**Planning Application 19/02796/FULL OS Parcels 3309 & 4319 adjoining LNMR**

Further to our previous letter of objection earlier this year please find below our additional response to the latest published amendments which include the site layout, car park lighting, roller shutters to the pavilion, MUGA fencing, ball stop fencing and additional tree and hedge planting.

1 North Elevation
1 : 100

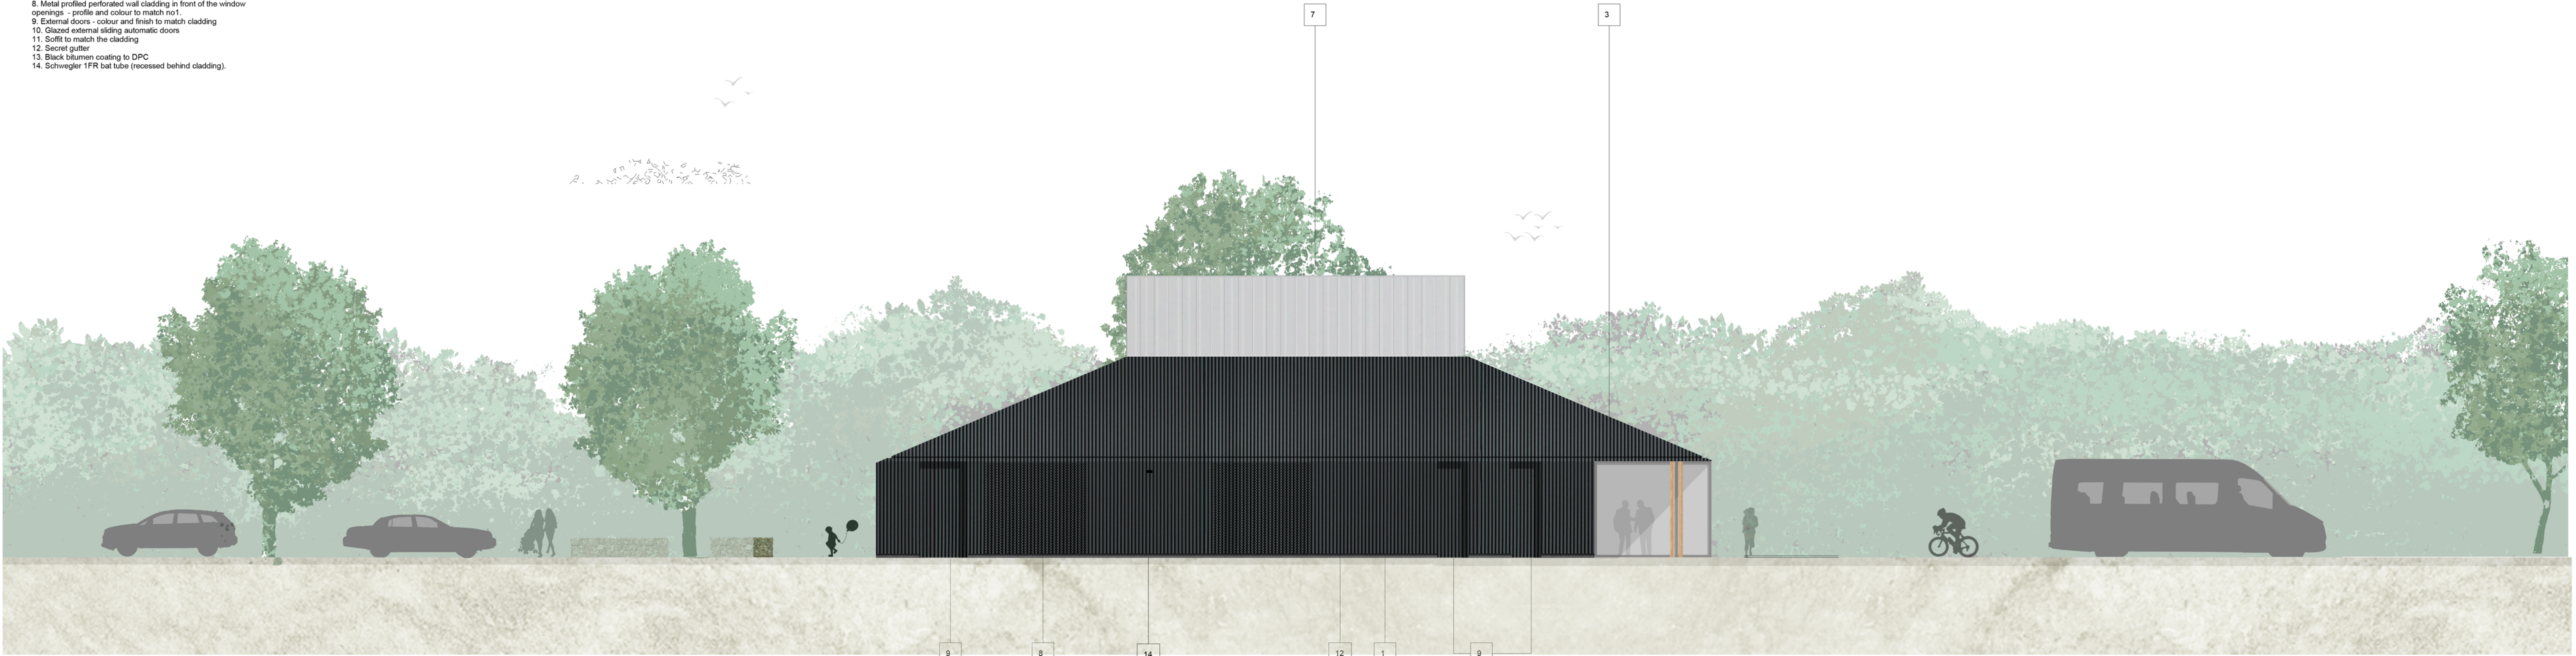
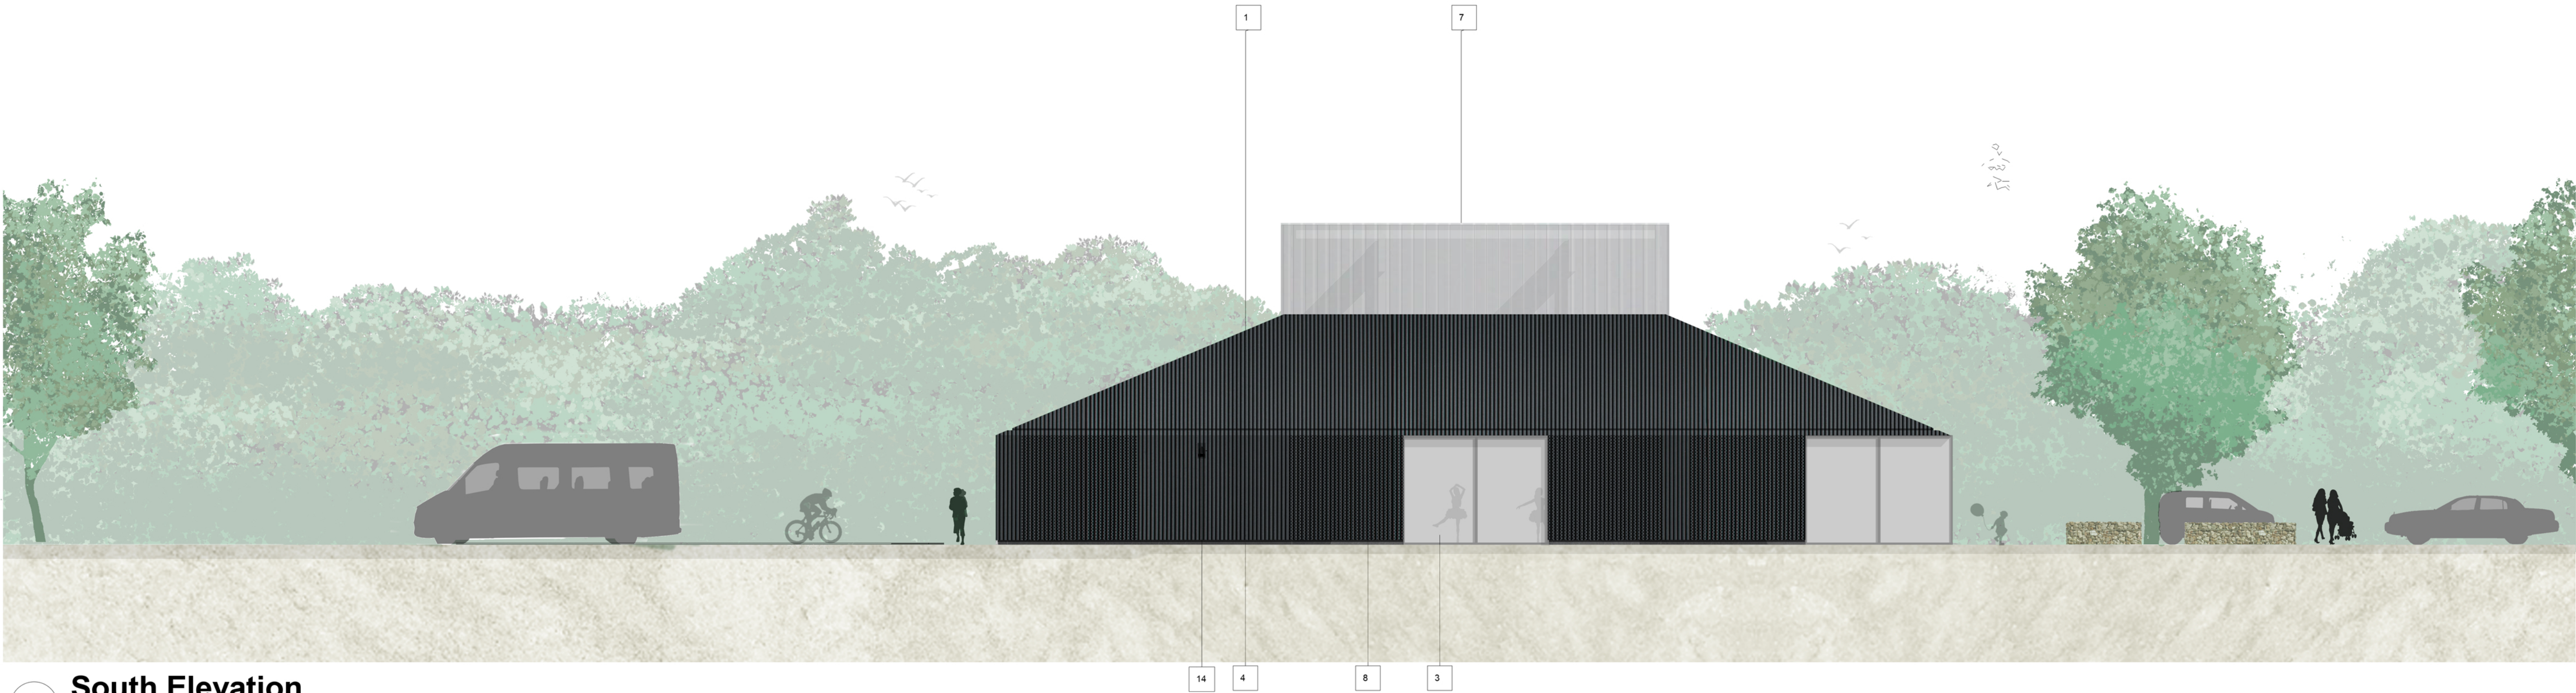
- We consider the proposed external facings of the pavilion and its construction materials ugly and inappropriate. Dark metal shutters are more suggestive of a penal facility than a vibrant community centre. The designers' claim that the dark colour will recede into the landscape like a rural barn are hard to reconcile with their assertion that it will also make a bold statement.
